DECISION DELEGATED TO HEAD OF PLANNING

Application No:	H14-1032-21	Applicant:	Executors of P J Borst Deceased c/o G B England Esq
Proposal:	Residential Development - 16 Dwellings - outline approval H14-0912-17		
Location:	Crossgate Lane Pinchbeck Spalding		
Terminal Date:	24th February 2022

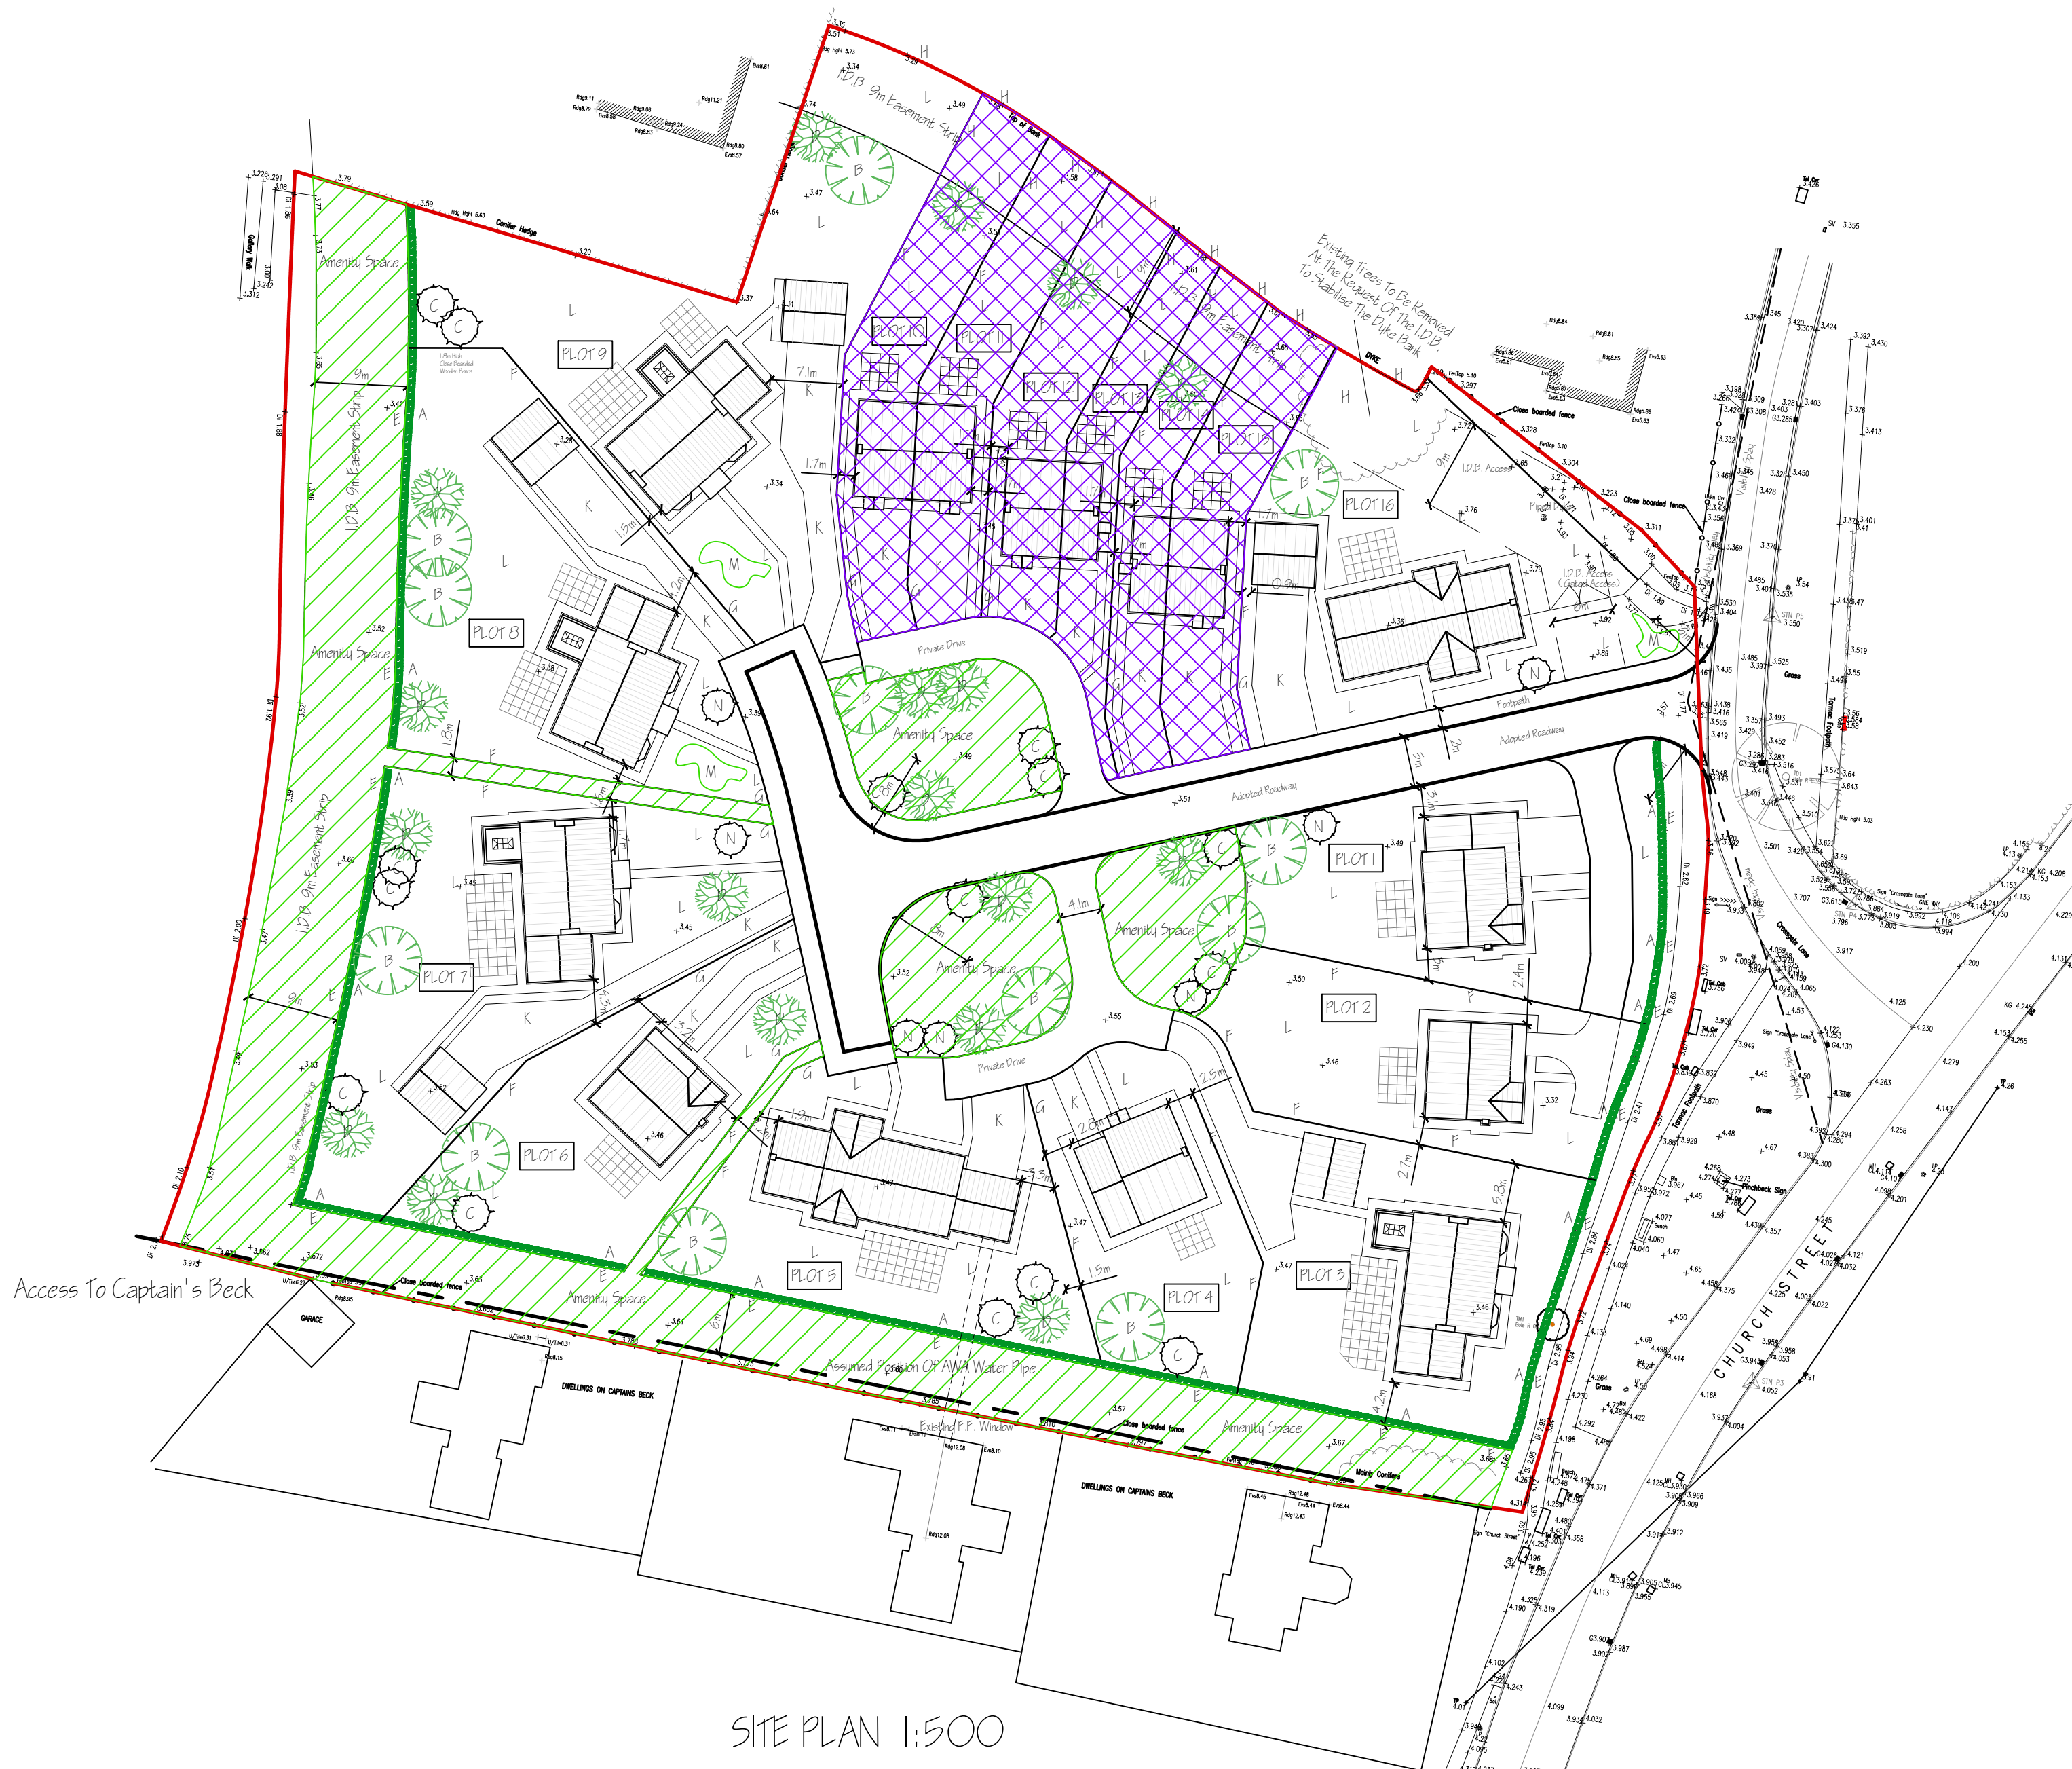
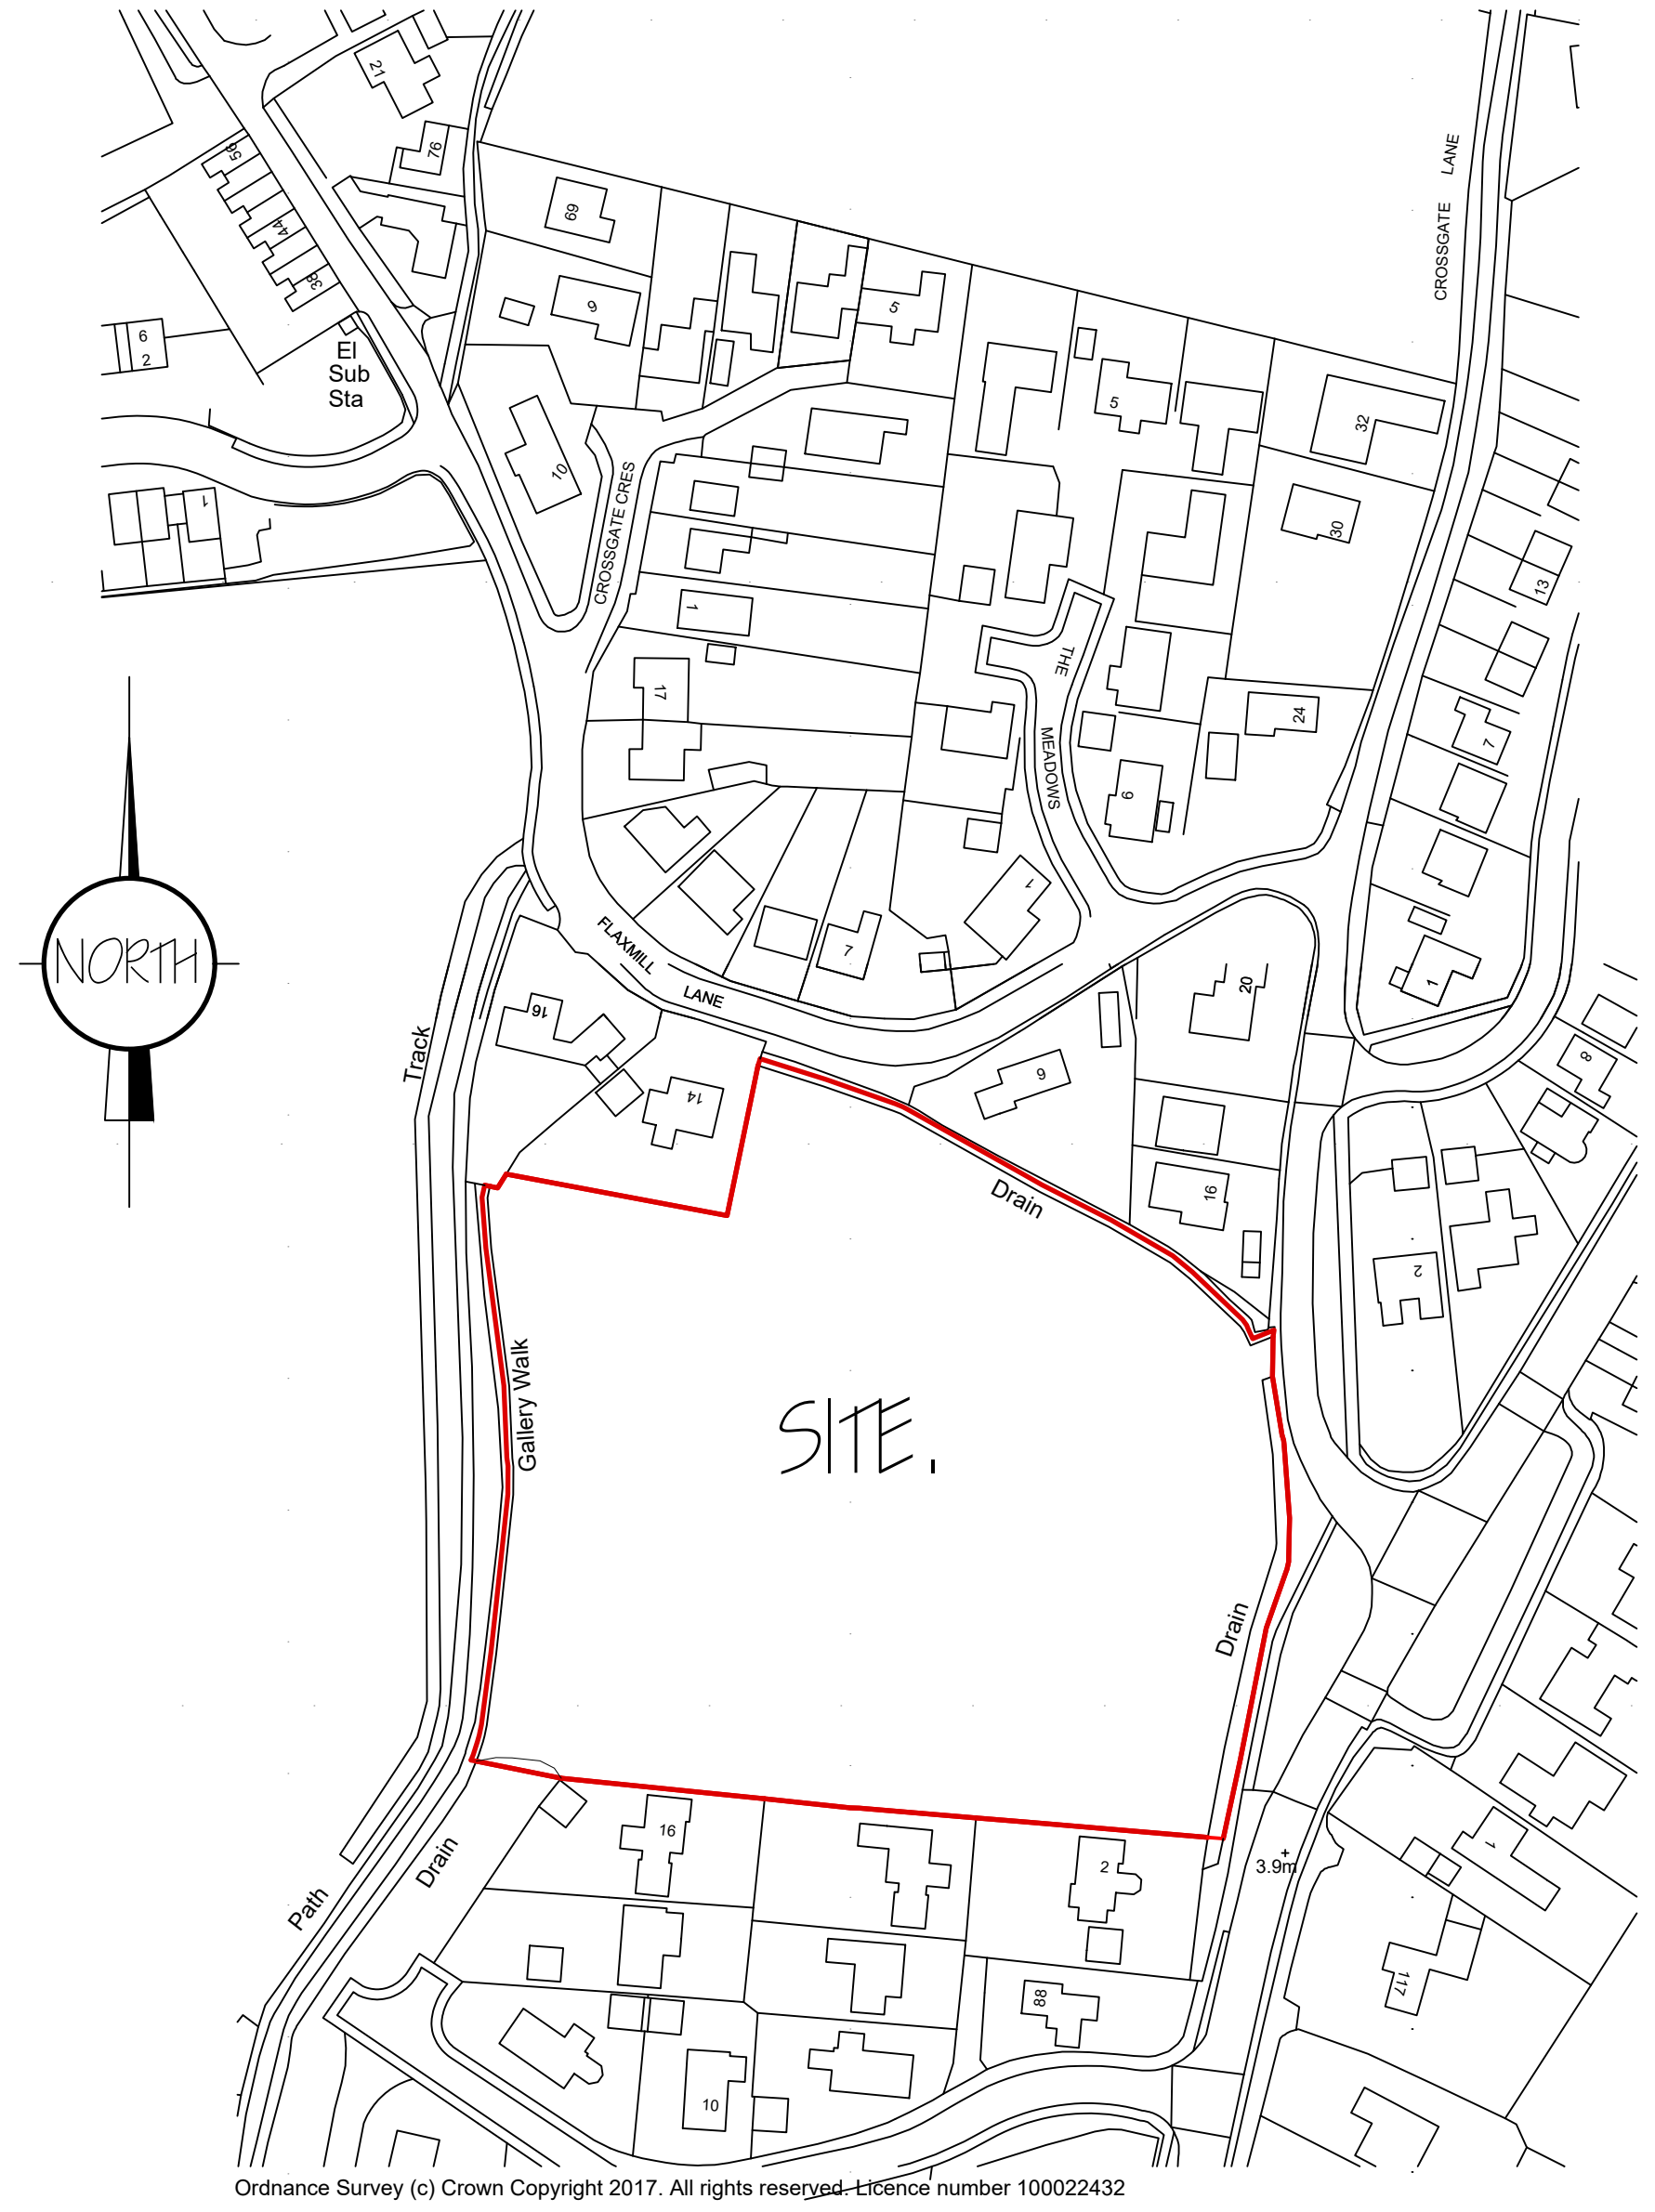
The applicant has submitted 3903-21 01D site plan which suggests that they are offering 6 x 3 bed houses for Intermediate Housing for the affordable housing contribution. Whilst this exceeds the 25% policy requirement, the applicant has not considered my previous comments to provide a mix of tenure and property sizes. Therefore, these current proposals do not accord with either Policy 17: Providing a mix of housing or Policy 18: Affordable Housing, and the applicant has not provided any reasoning for this.

Further to my previous comments the applicant has now provided additional information on the affordable housing scheme in the "additional information re affordable housing" and the revised floor plans for the proposed affordable plots 10-15. Within this they propose 4 Rented dwellings, comprising of 2 x 1 bed houses and 2 x 2 bed houses and 2 Shared Ownership dwellings comprising of 2 x 3 bed houses. All of these are proposed at the nationally described space standards which is recommended but not a policy requirement. The proposed affordable housing scheme does now accord broadly with policy and will contribute to meeting housing needs in the area and district as a whole.
